Application for a non-material amendment following a grant of planning permission.

single storey rear extension.
new second floor dormer roof to provide master bedroom suite.
alterations to front elevation, including replacement garage, porch to front door, new slate roof finish, raised roof eaves to provide enlarged first floor and rendered and horizontal weather boarding to front and rear elevations.

render finish to east and west elevations to match north and south elevations.

ARON DISTRICT COUNCIL BR/95/19/NMA

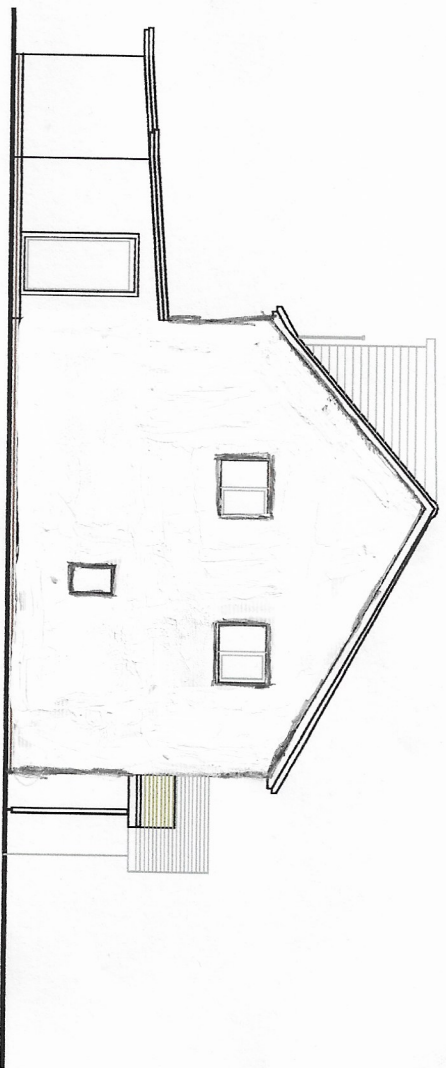
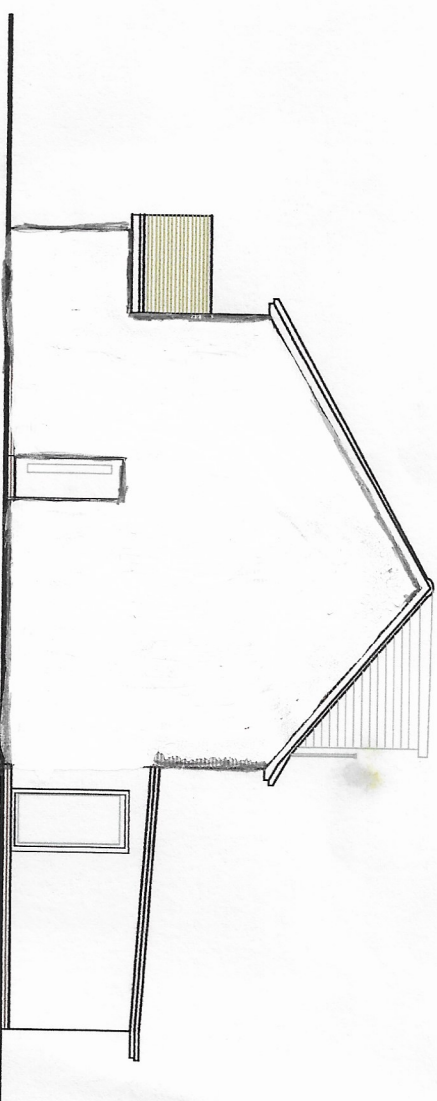
Remedial wall ties had to be installed on all elevations due to corrosion of existing wall ties, which resulted in bulging and cracking of brickwork. during the process of the wall ties being installed they were drilled through the centre of the bricks leaving a 10mm hole in hte brick and there are 357 new wall ties. resulting in damaged brickwork mainly on the east and west elevations.
